From: Jeff Thomas <jeff.thomas@mercerisland.gov>
Sent time: 2022/06/16 09:36:26 PM
To: Kate Miller <kate@brandtdesigninc.com>
Cc: Colin Brandt; Bree Medley <bree@brandtdesigninc.com>; Andrew Leon
Subject: RE: Building Permit No. 2109-150
Attachments: FW: Building face /height question RE: Permit # 2109-150 Clarifications 220510_2109-150_HeightCoordinationPackage.pdf

This message is responsive to your request for clarification related to Building Permit No. 2109-150, specifically the application of Mercer Island Municipal Code (MICC) 19.02.020(E)(2) for maximum building height on downhill building façade. We discussed the matter at issue during a video meeting on May 26, 2022. MICC 19.02.020(E)(2) requires maximum building height on downhill building façade as follows:

SCALE: 1/4" = 1'-0"

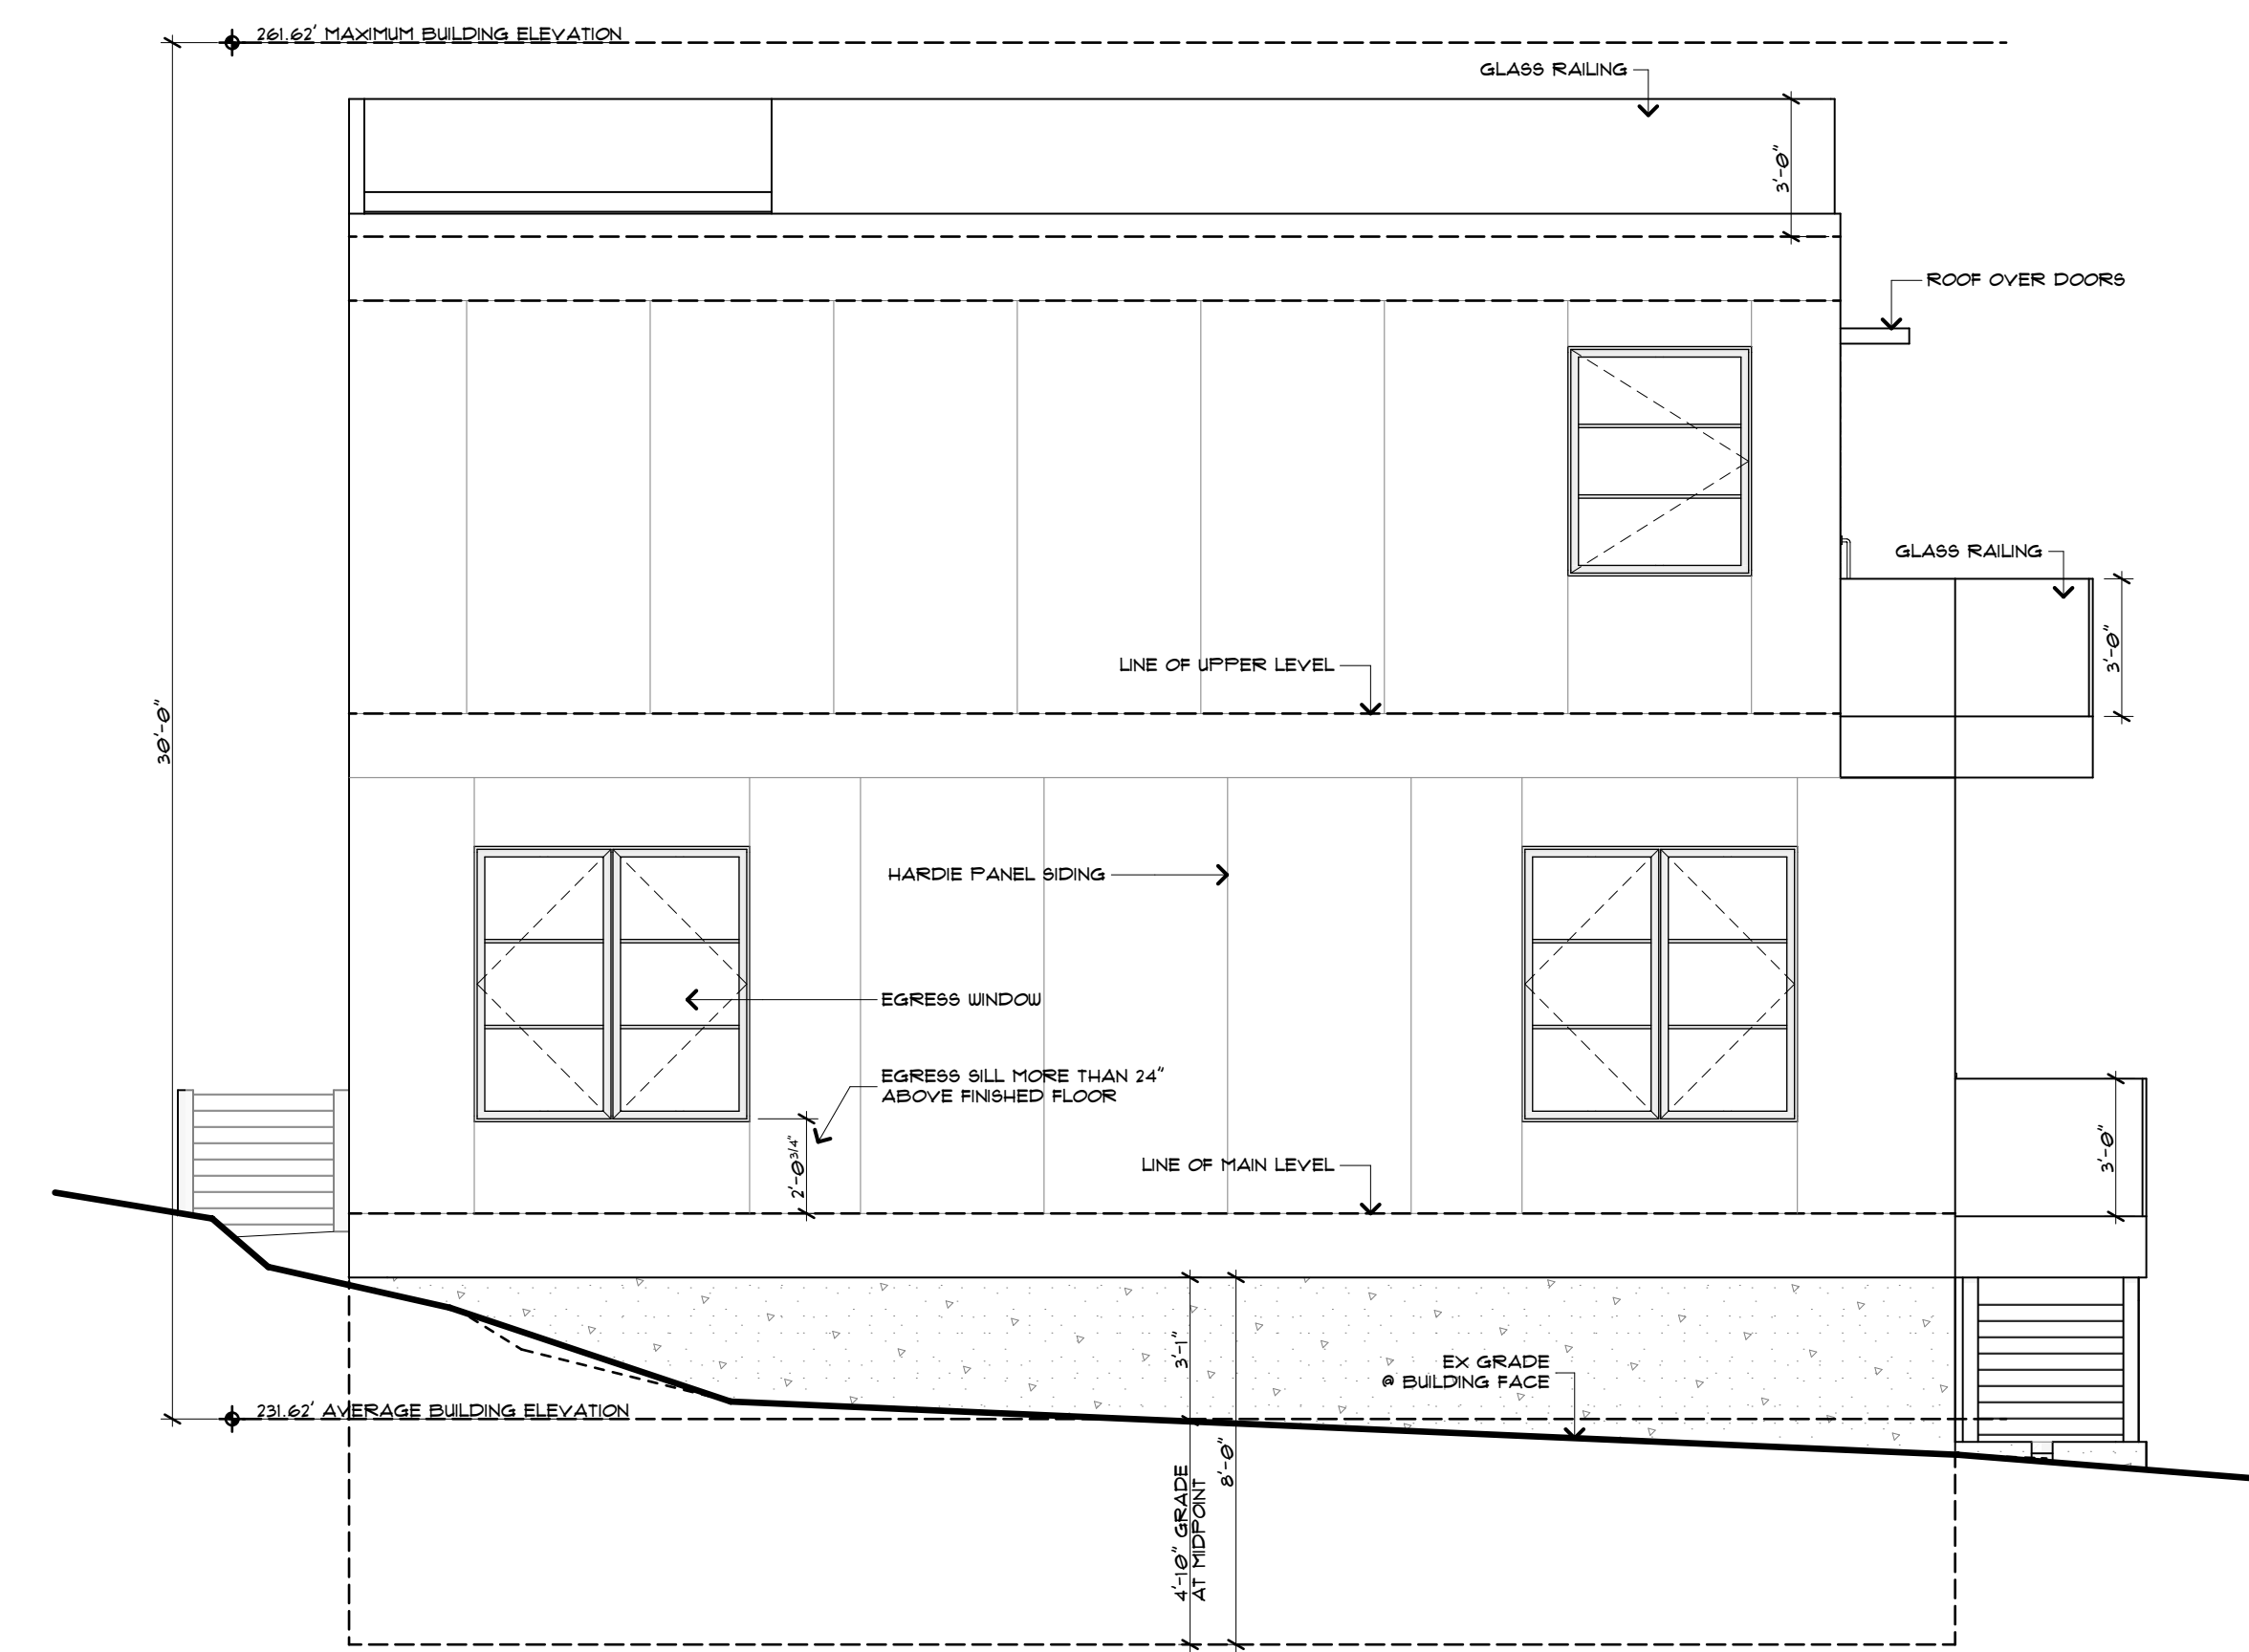
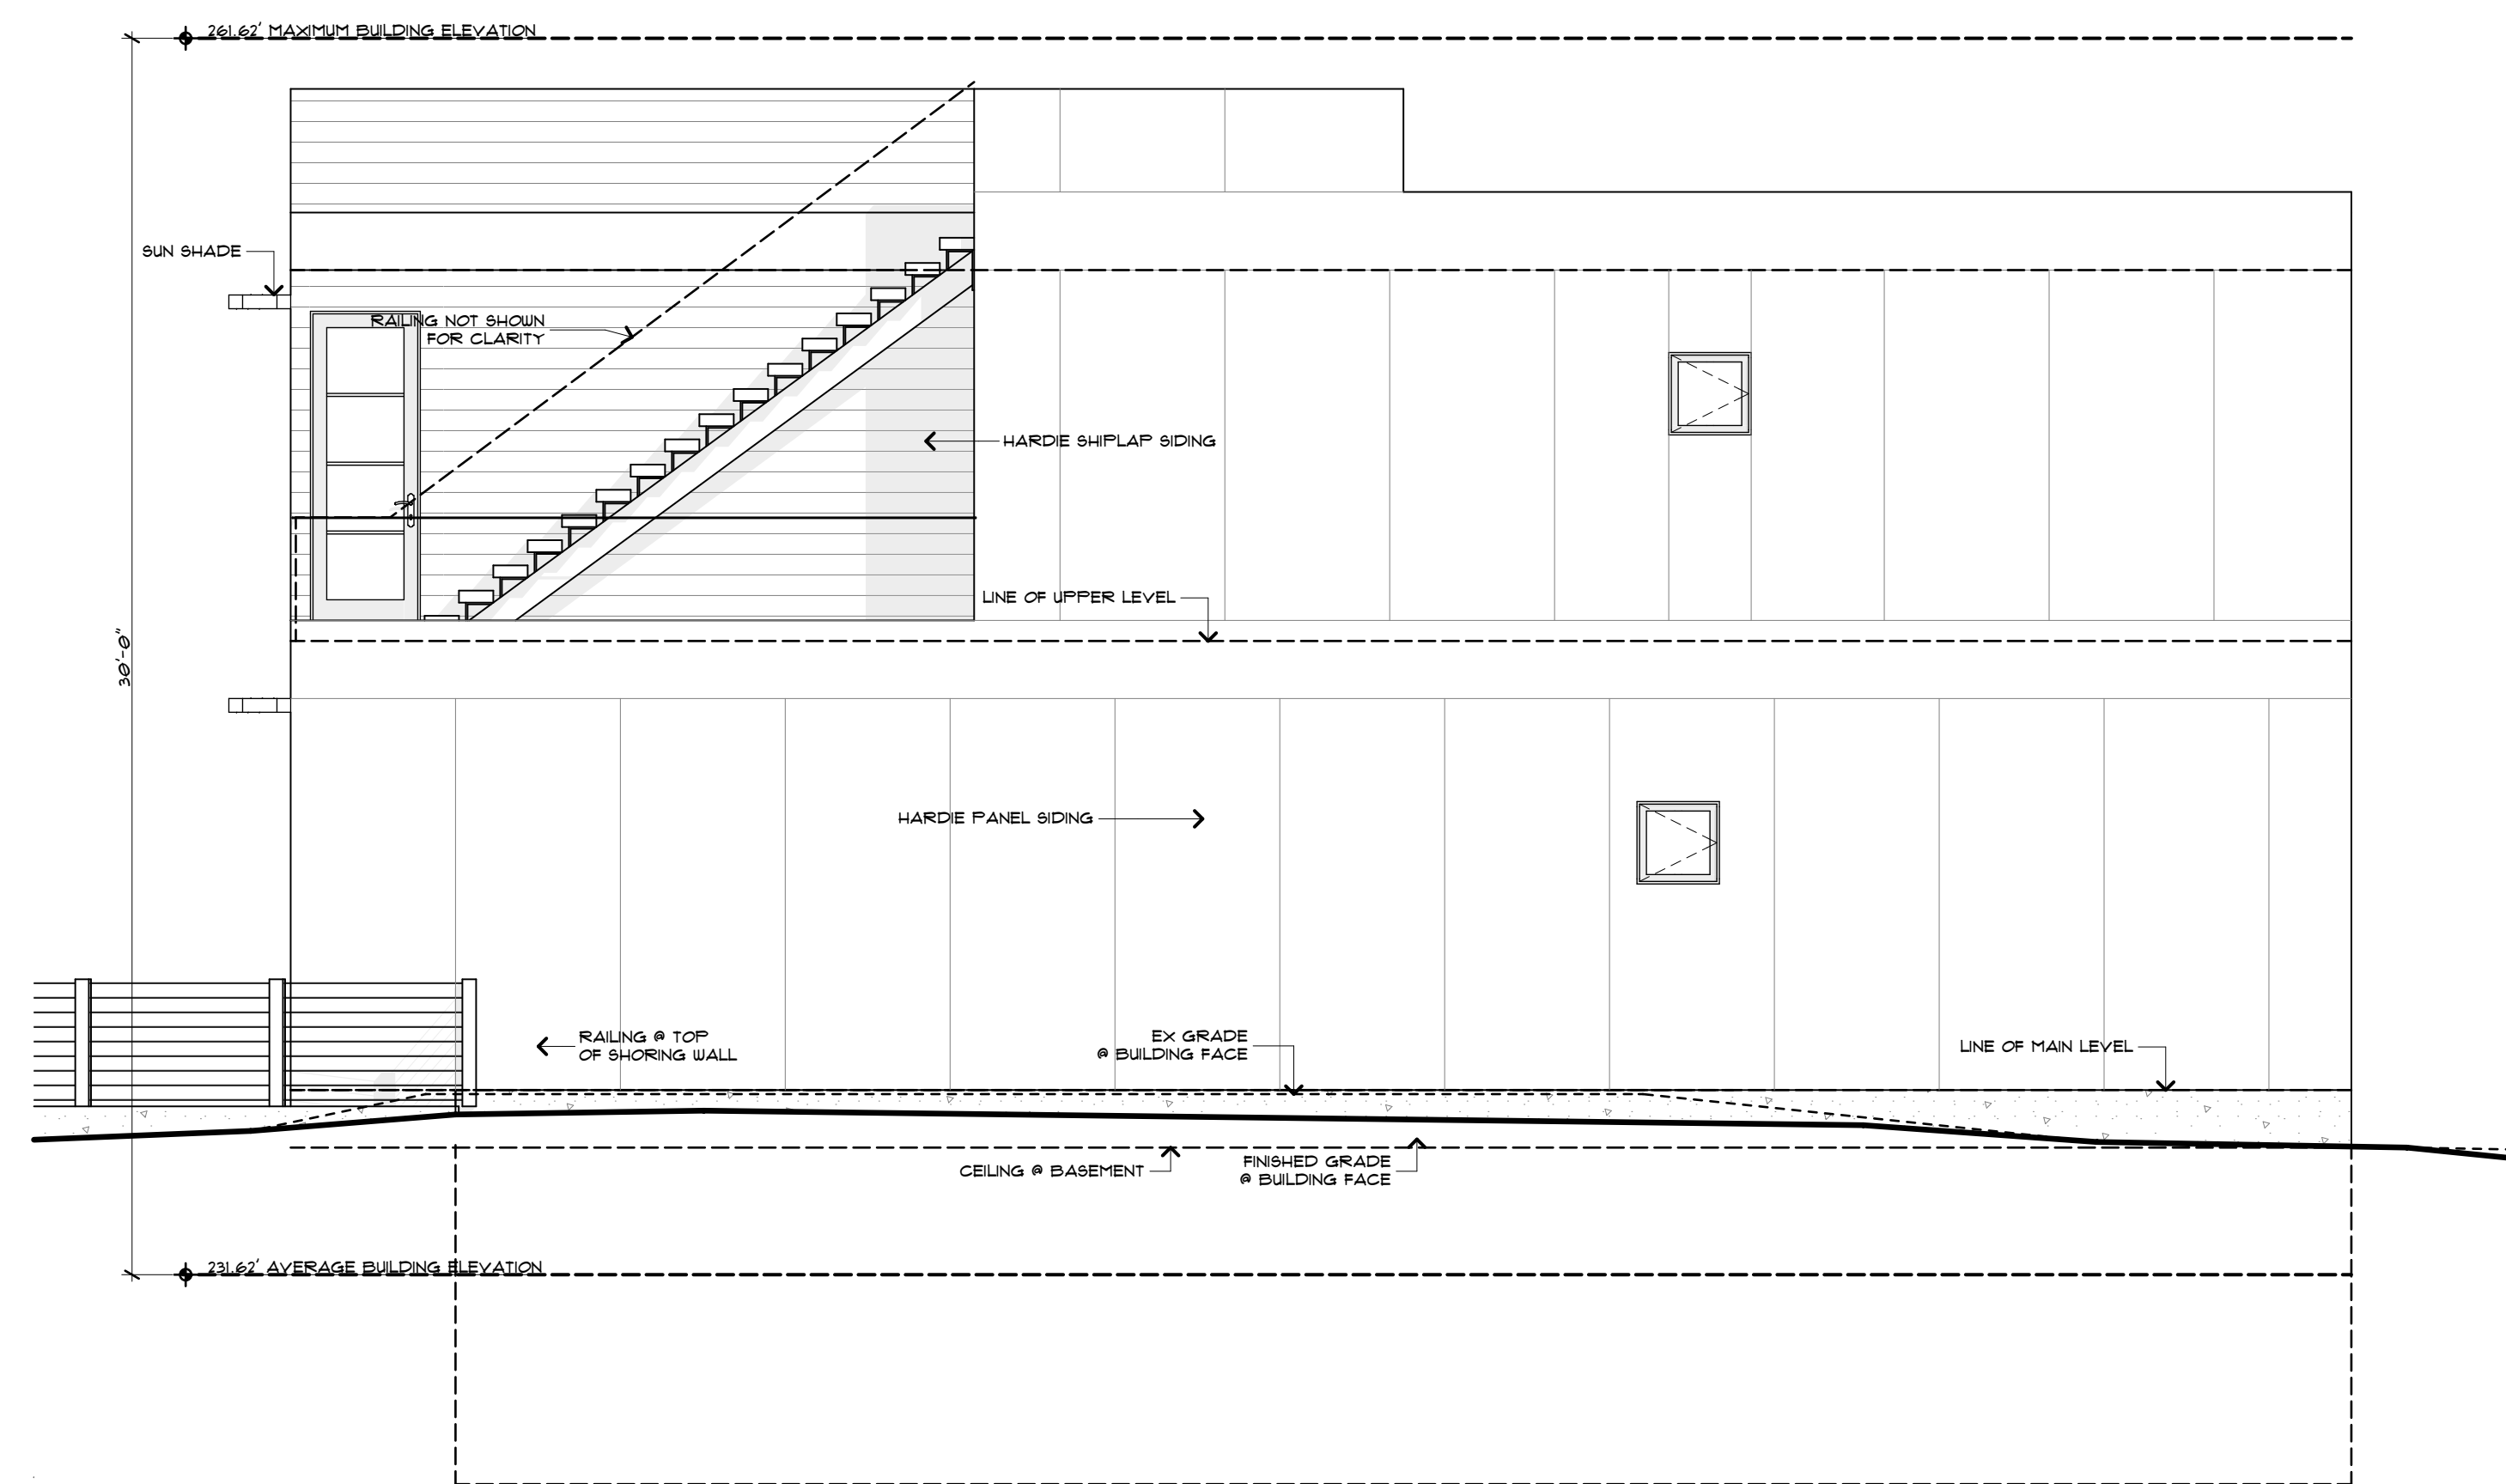
2. The application of MICC 19.02.020(E)(2) to the proposal contained within Building Permit No. 2109-150 results in a building height on the downhill building façade of 33-feet, 6-inches (see attached).

3. MICC 19.02.020(E)(2) does not contemplate multiple building facades or exterior wall facades on the downhill side of a sloping lot – only the maximum building façade height as a singular treatment, the exterior wall façade supporting the roof framing, rafters, trusses etc.

6. Therefore, in the absence of further direction in the MICC, there are two options to resolve the building height on the downhill building façade of 33-feet, 6-inches for Building Permit No. 2109-150:

- A. Revise this application to comply with MICC 19.02.020(E)(2) 30-foot requirement; or
 - B. Apply for a Zoning Variance to seek relief from this requirement.
